From: Colin Chandler [REDACTED]
Sent: 07 November 2018 18:11
To: Planning.Responses
[REDACTED] Karl Roberts; Cllr. Paul Bicknell; Cllr. Andy Cooper; Cllr. Dudley Wensley
Subject: 53 Mill Road Avenue

Re: 53 Mill Road Avenue, BN16 4HX

Applications: A/128/18/CLE and A/132/18/HH

PROPOSED ELEVATIONS 1:100

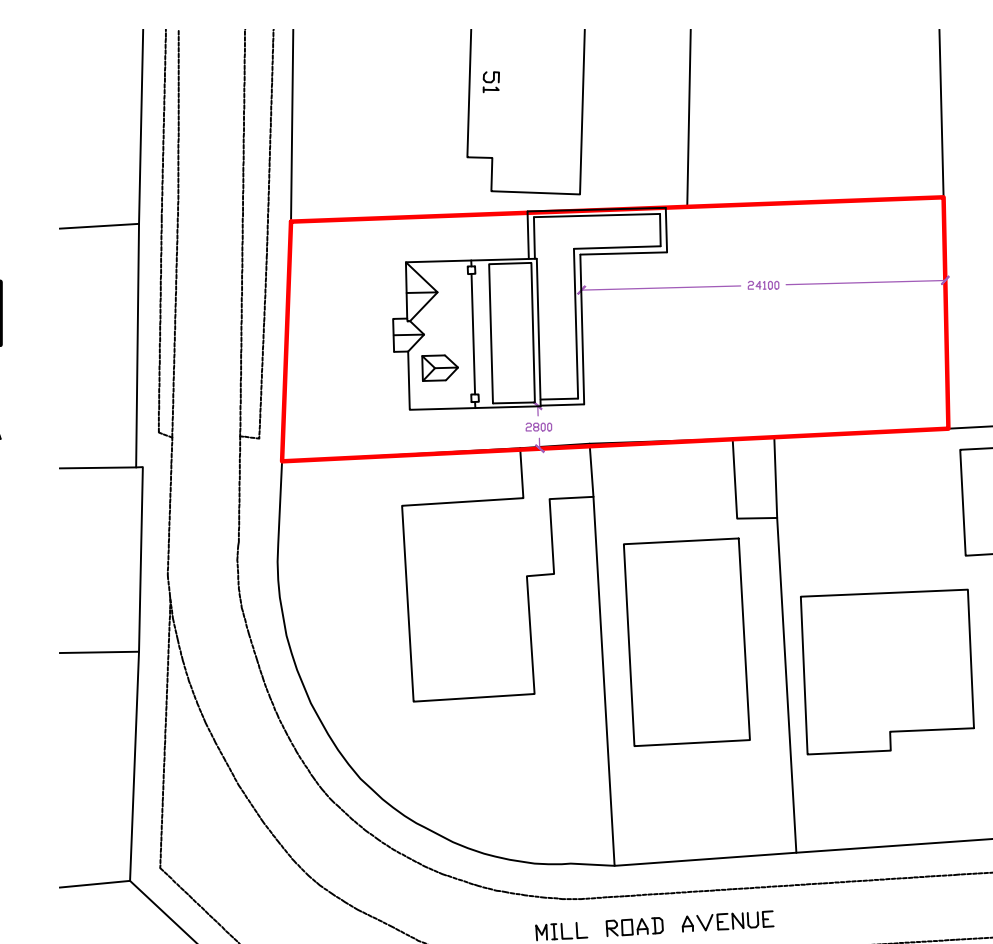
The Parish Council (PC) on 30/10 resolved to raise no objections to the current 3 applications at the above site. Regrettably, we could not attend that meeting but from neighbour feedback we remain concerned that material considerations were not taken on board. Our primary concern is the proposed use of horizontal cladding (mock timber) on the recently extended dormer.

"the face and sides of a dormer window should be finished using materials that give a similar visual appearance to existing house. So the materials used for facing a dormer should appear to be of similar colour and design to the materials used in the main roof of the house when viewed from ground level. Window frames should also be similar to those in the existing house in terms of their colour and overall shape."

Both those decisions make it clear that weatherboarding and zinc (as examples) are not *similar* or appropriate materials in the context of traditional tiled roofs, as exists on and about No.53, to attract the benefit of Permitted Development.

We see that since making our previous representations and the PC's consideration, two sets of French doors and two windows have now been installed and finished in grey - a colour that does not accord with other existing windows. That work also now appears to mean the test of lawfulness should fail, aside from the fact the openings bear little resemblance to that shown on the submitted drawing.

To be consistent and noting the particular restrictions on roof level changes, we believe that application A/132/18/HH for planning permission, (no doubt submitted in anticipation of A/128/18/CLE being refused) to clad the newly extended dormer at No.53 with similar cladding to that which was previously rejected should also be refused. The impact on the character and appearance of the surrounding area, as well as the No.53 itself, is demonstrated in the photo taken from our own similar dormer. (No.53, is on the left, showing their dormer before recent additions.) This application remains incomplete without a proposed rear elevation of the dormer.

As previously stated, there is a perfectly acceptable alternative to 'dress' the dormer with traditional tile hanging, subject to suitable *similar* colour choice.
